May 9, 2023

**RE: The Springs of Ballentine – Fire Sprinkler  
Fuquay-Varina, NC – Harnett County**

Plans relative to the above-named project received on April 27<sup>th</sup>, 2023 have been reviewed for general compliance with the 2018 North Carolina Building Code and the National Fire Protection Association (NFPA 13) Standard for the Installation of Sprinkler Systems, 2013 edition. Per Chapter 23 of this standard, the following shall be submitted with working plans to perform a complete review.

Date:
02/13/2023

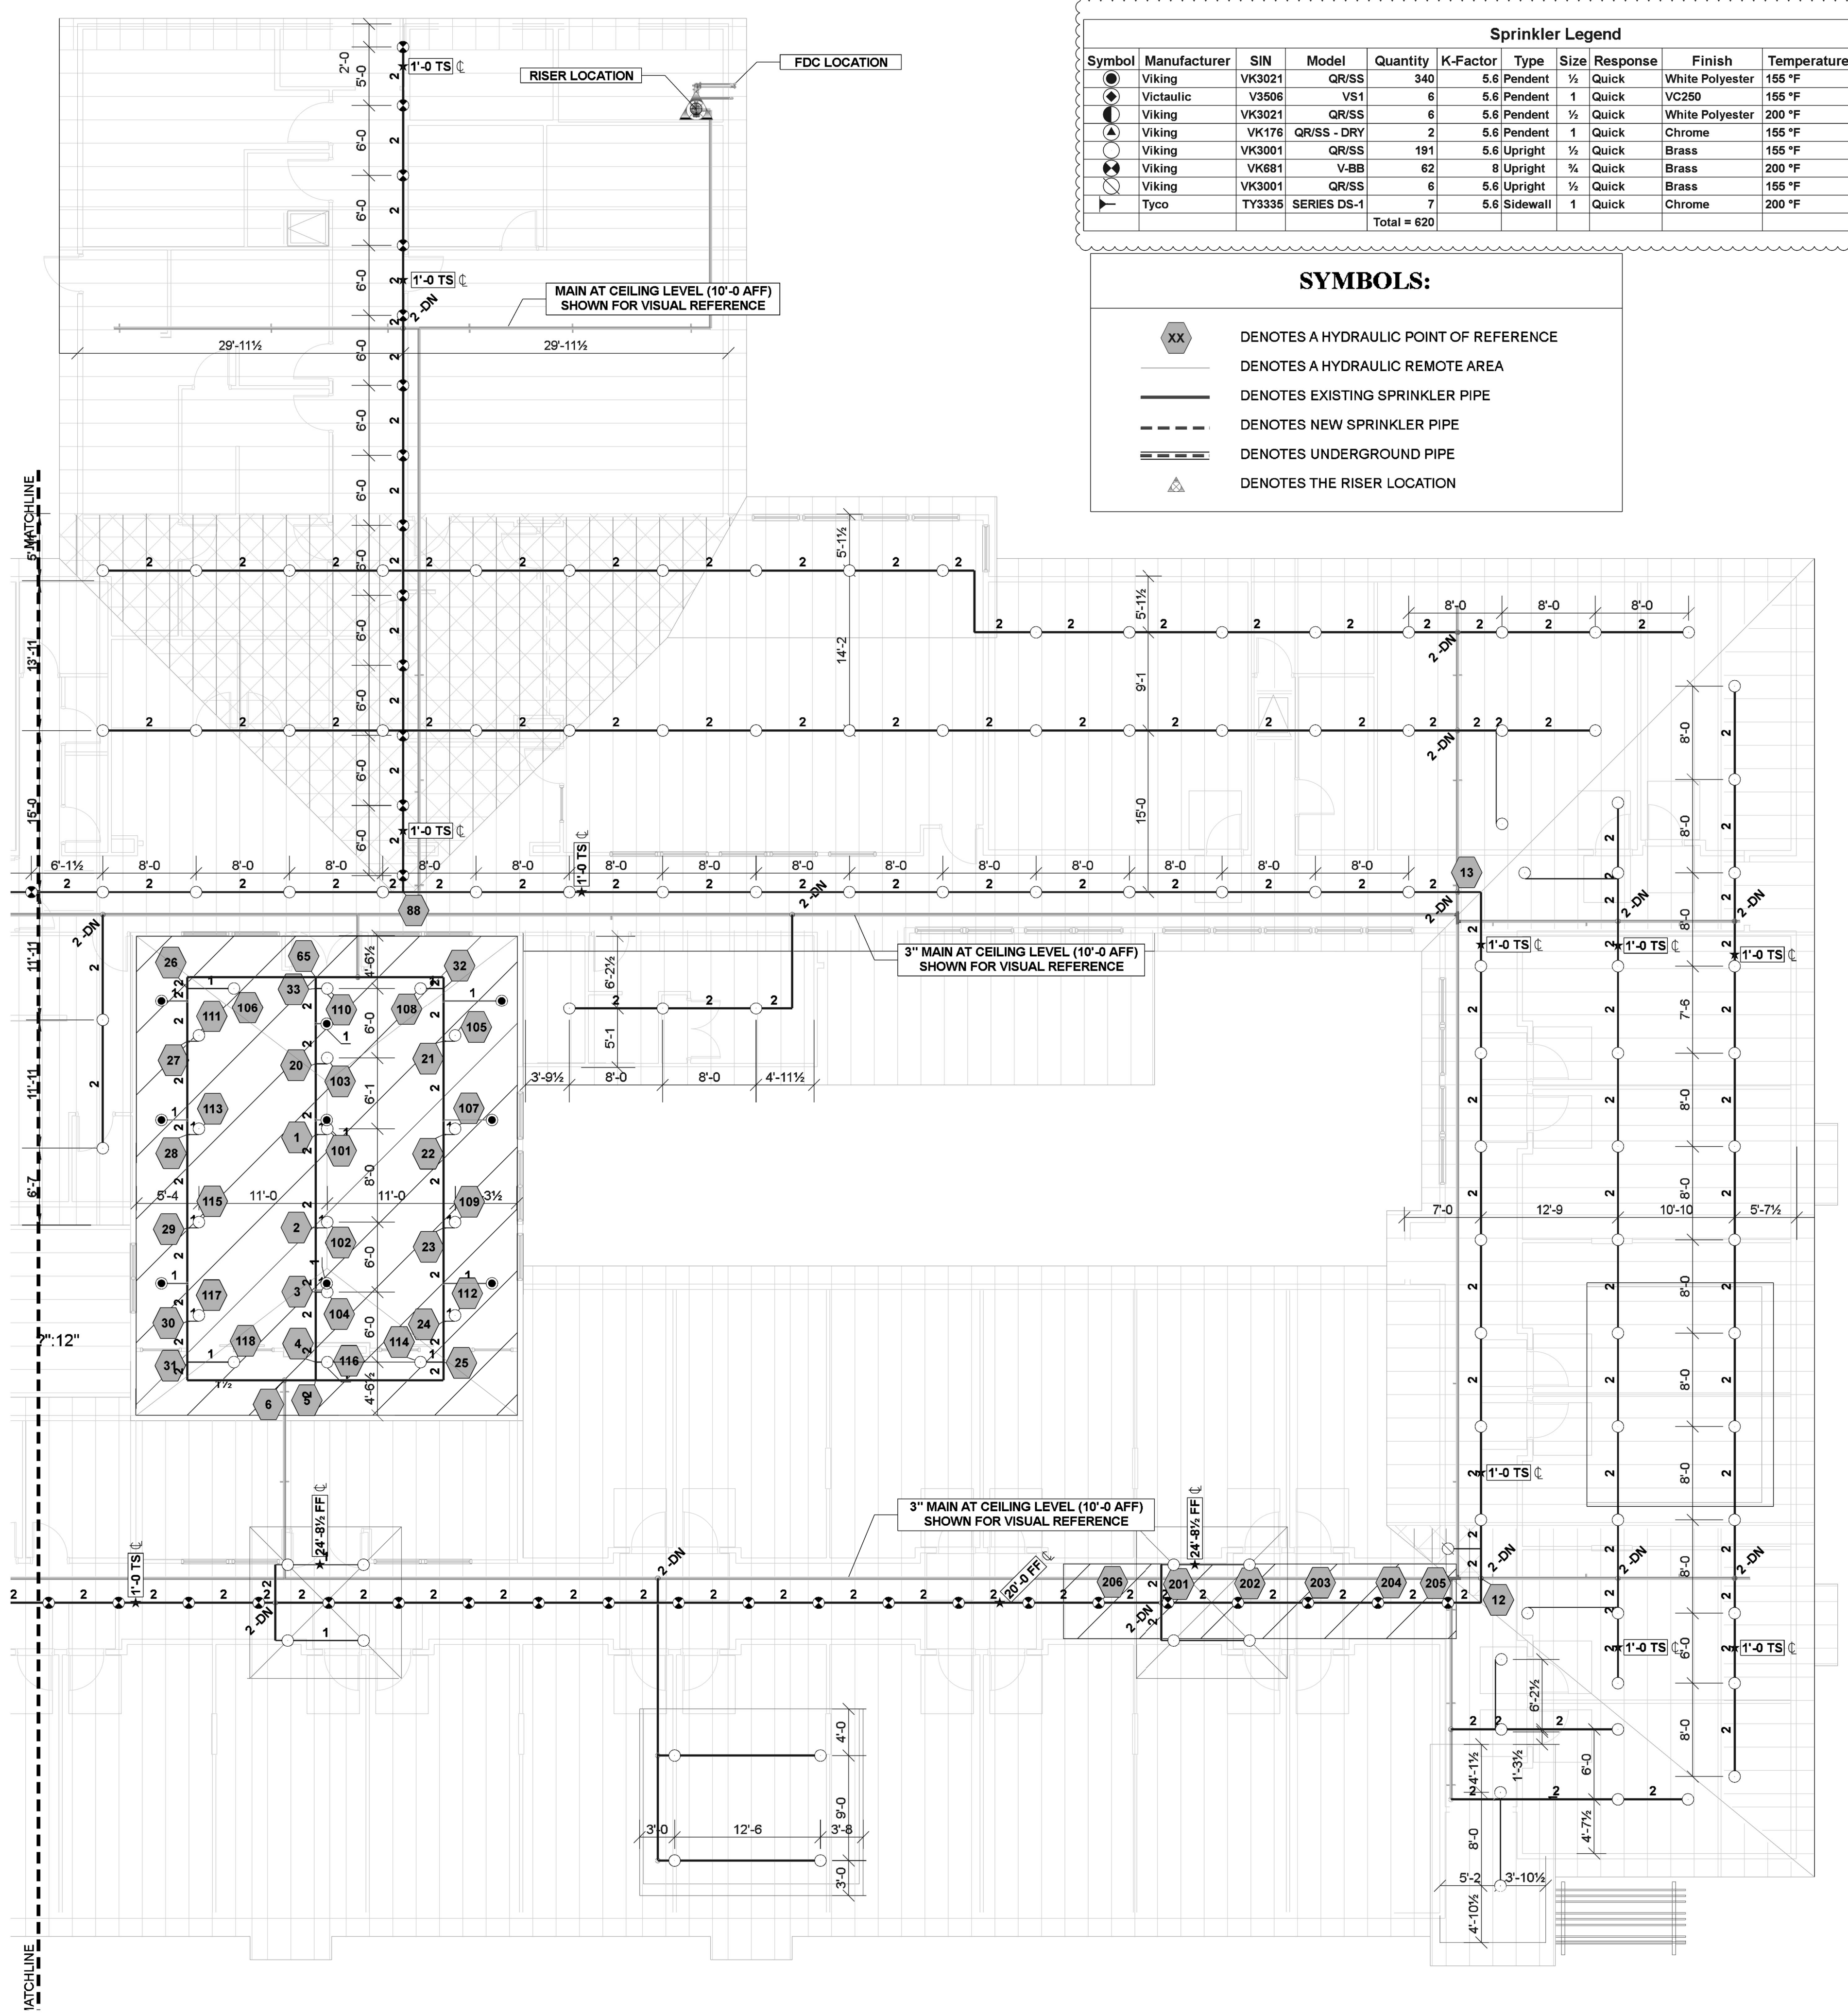
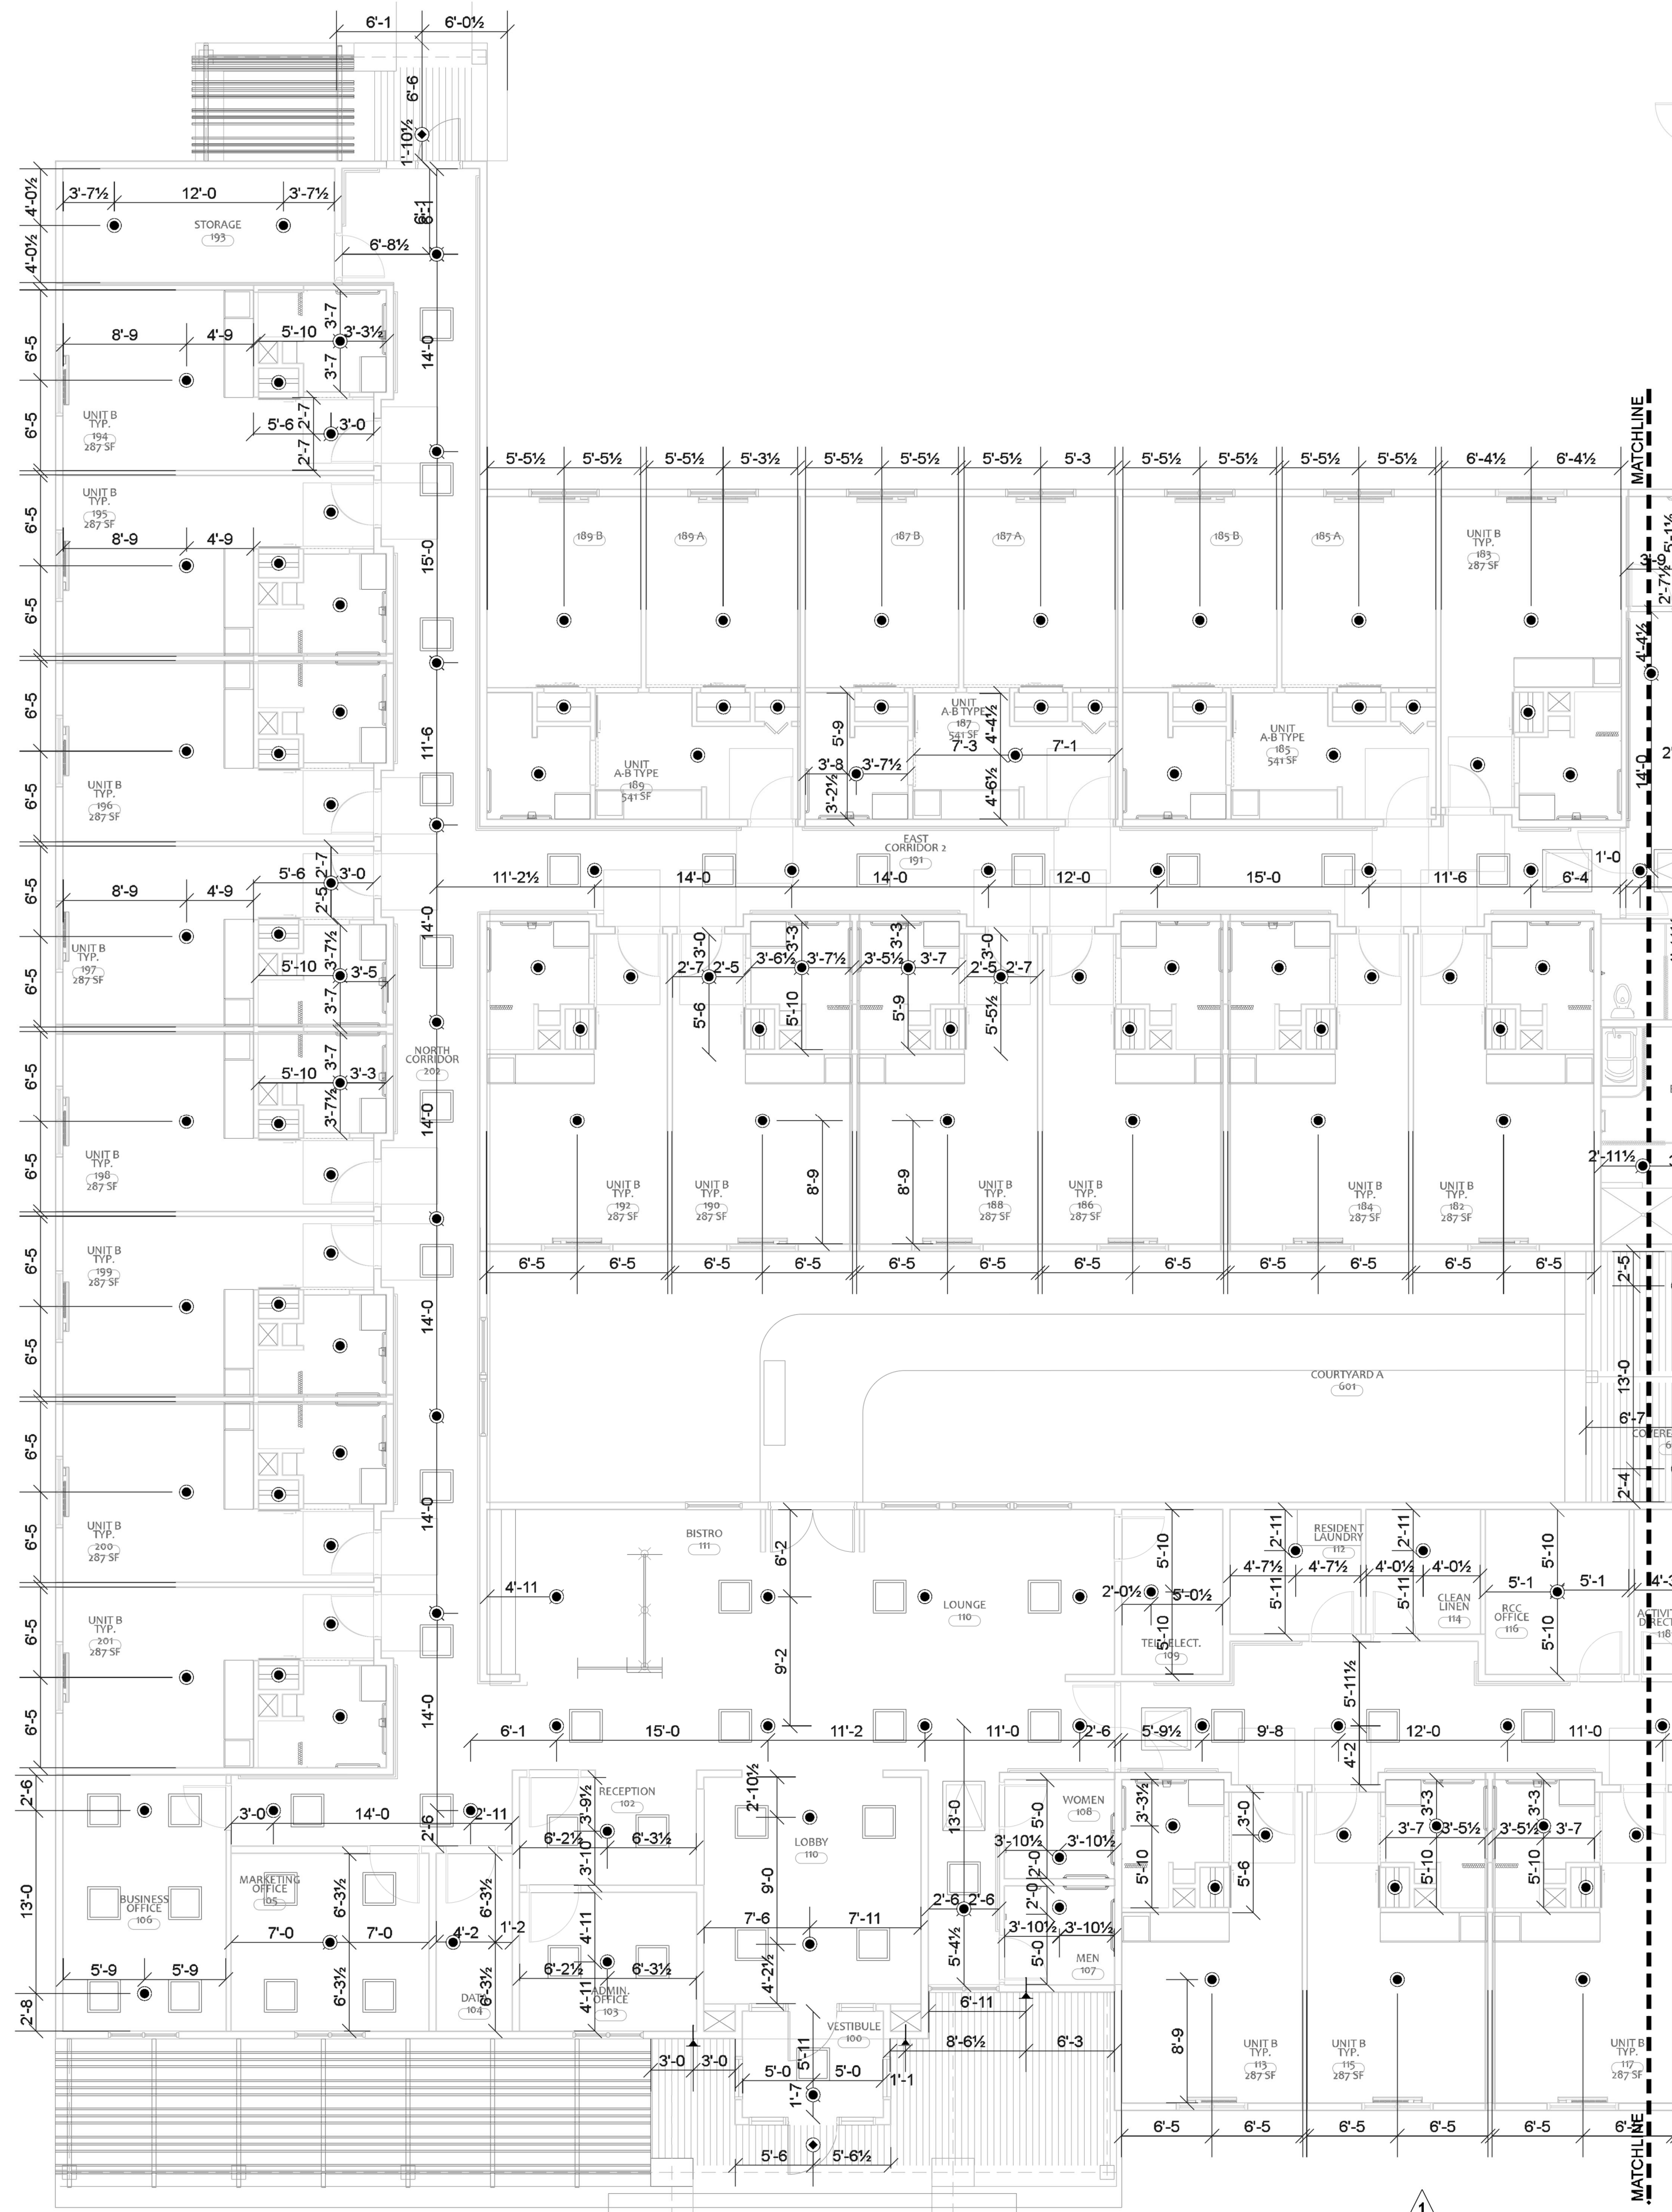
3. Are there any small enclosures in which no sprinklers are to be installed (near Apothecary 176 & Servery 159?) per NFPA 13, Chapter 23, section 23.1.3 #9.

5. Provide total area protected by each system on each floor per NFPA 13, Chapter 23, section 23.1.3 #14.
6. The head count for the Victaulic V3506 appears to not match the plans (too low). Please confirm. This may also impact Viking head VK3021.

7. The sprinkler head outside rear entry near Electric Room 169 appears to not be the correct symbol for the intended head.

8. The symbol for the heads provided in Activity 162 and Lobby 110 are not listed in the Sprinkler head legend.
9. Provide cut sheets for inspectors' test connections per NFPA 13, Chapter 23, section 23.1.3 #23.

10. Show location of the inspectors' test valve on the plan view.
11. Provide cut sheets and location for alarm bells per NFPA 13, Chapter 23, section 23.1.3 #26.
